LATE SCOPING CONSULTATION RESPONSES

Application by North Somerset Council for an Order Granting Development Consent for the Portishead Branch Line (MetroWest Phase 1)

From: Deputy Clerk [<mailto:deputyclerk@portishead.gov.uk>]
Sent: 13 August 2015 13:10
To: metrowest@westofengland.org
Cc: Environmental Services
Subject: Metrowest Phase 1 - Consultation on Portishead Branch Line

2.15 to 2.17 - Trinity Footbridge plans: Proposed General Arrangement Plan; Proposed Landscaping General Arrangement Plan; Electrical Layout General Arrangement

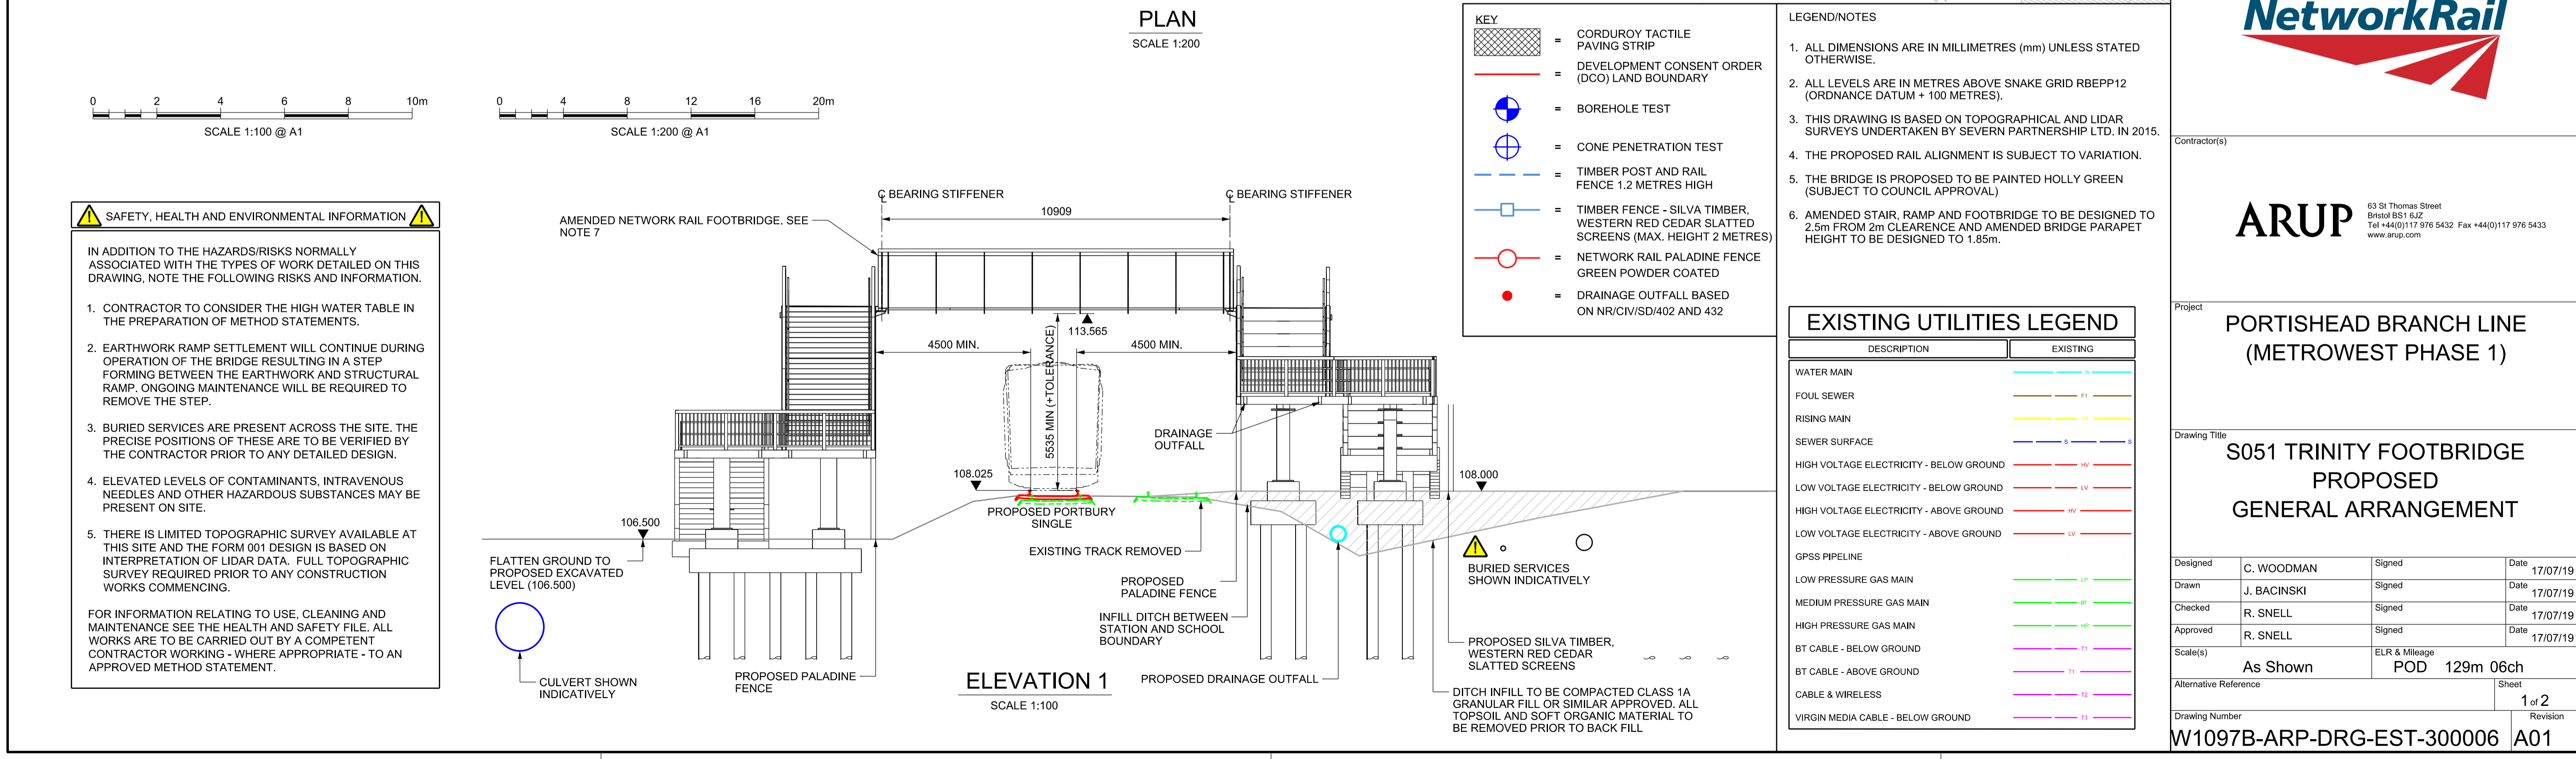
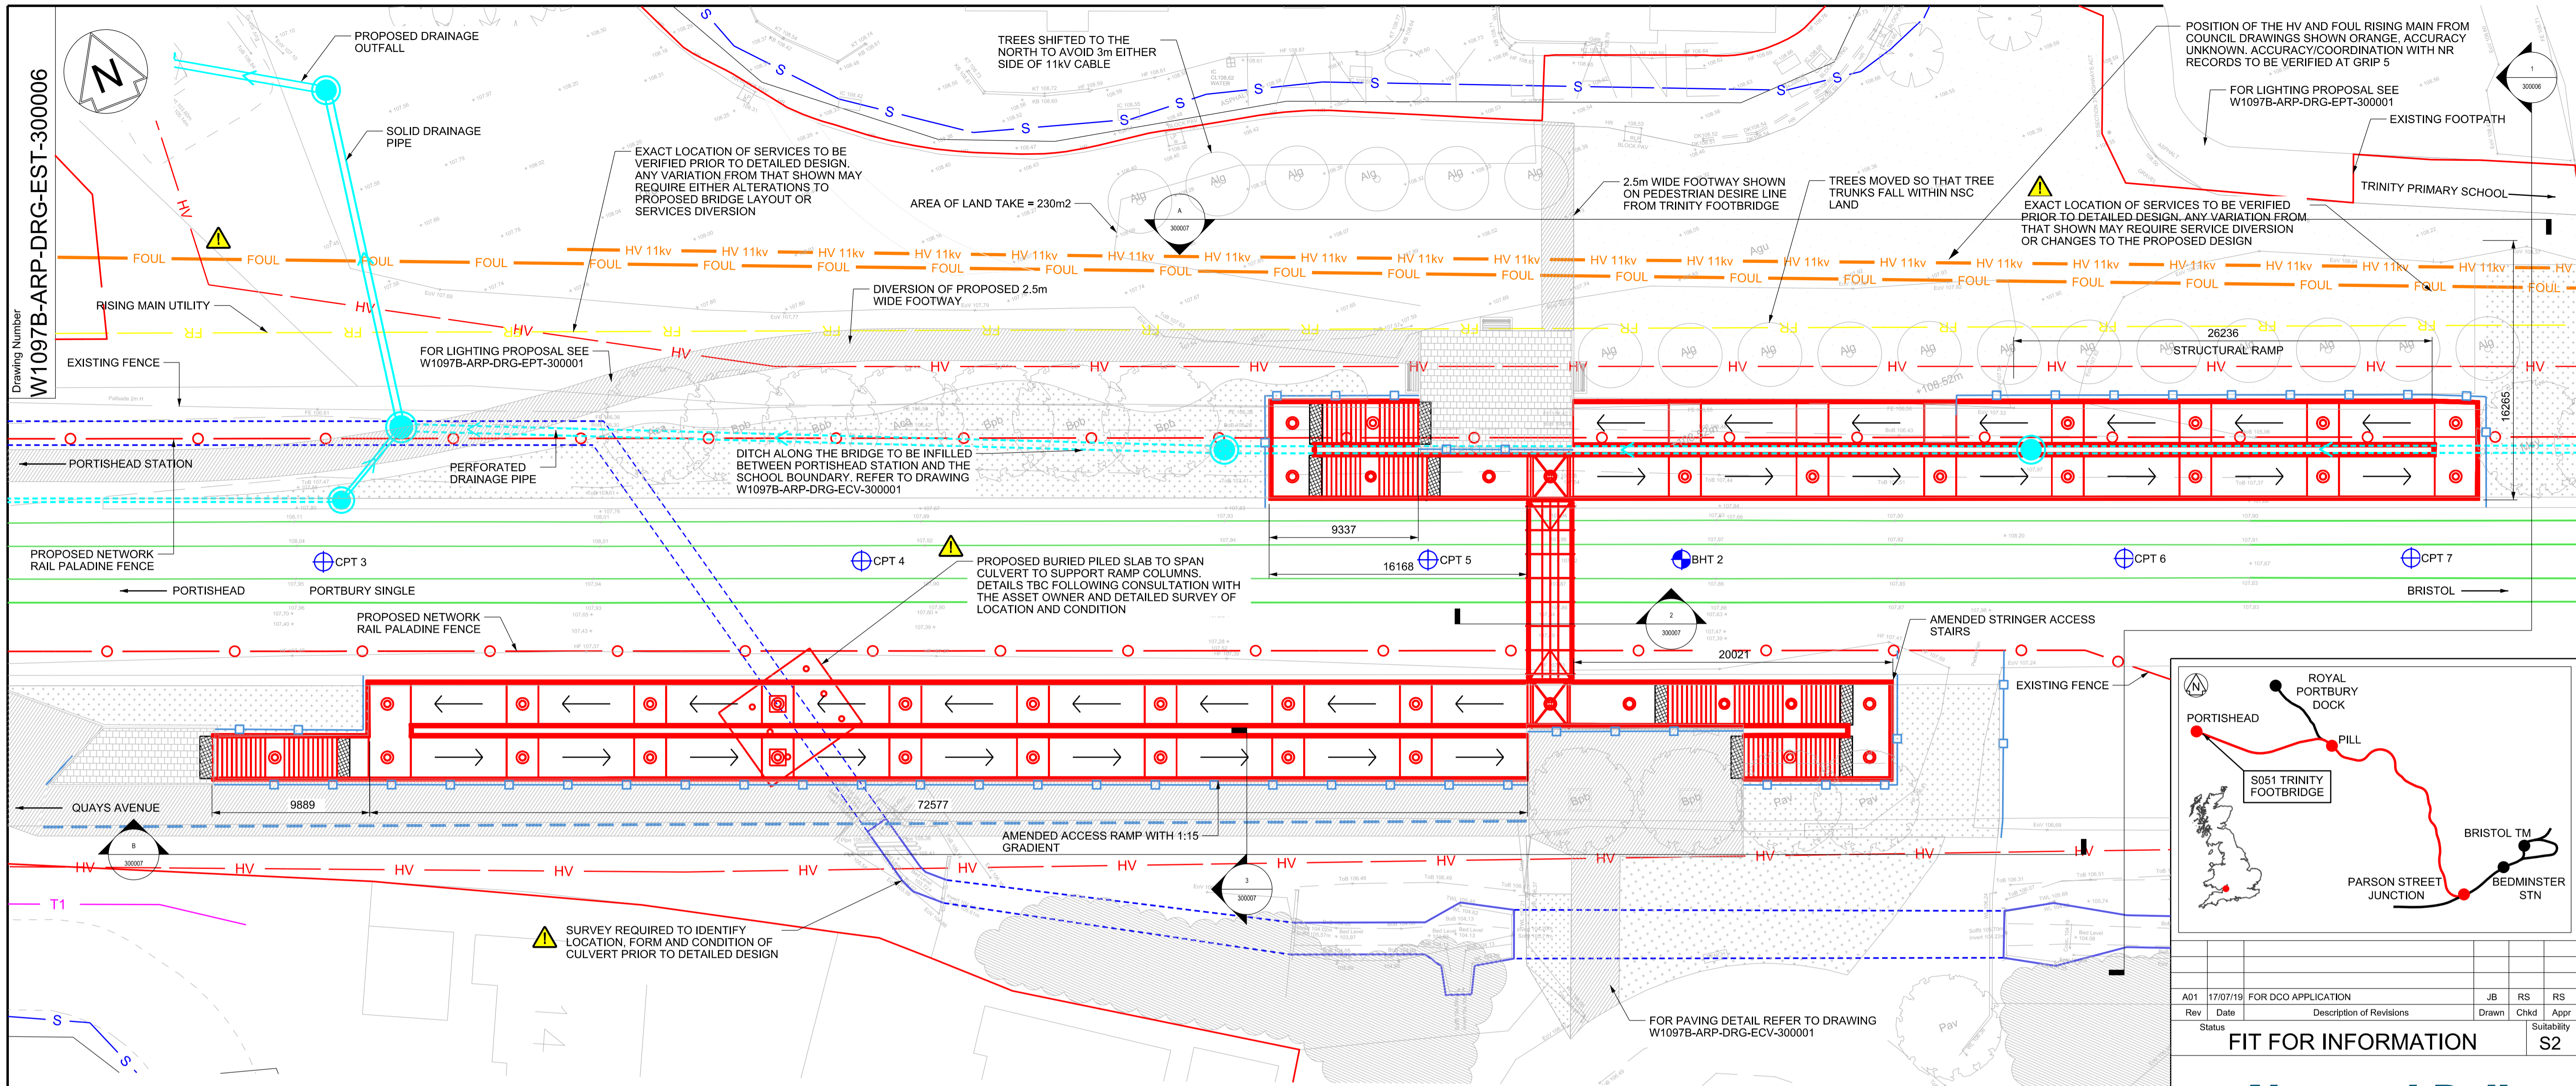
1. Substantial on street parking will be lost in the vicinity of the Health Centre on Harbour Road when the scheme goes ahead. Can parking provisions be made for visitors to the health centre.
2. To include provisions for cyclists using the trains.
3. Concern for the structure of the sloped footbridge (by Trinity school) for wheelchair users.
4. Arranging parking provisions for construction traffic to eliminate already congested onstreet parking, particularly in The Vale.
5. Introduce a minibus around the Town linked to the train times.
6. Displaced parking. Drivers wishing to avoid parking charges park in local residential roads for free causing a nuisance.
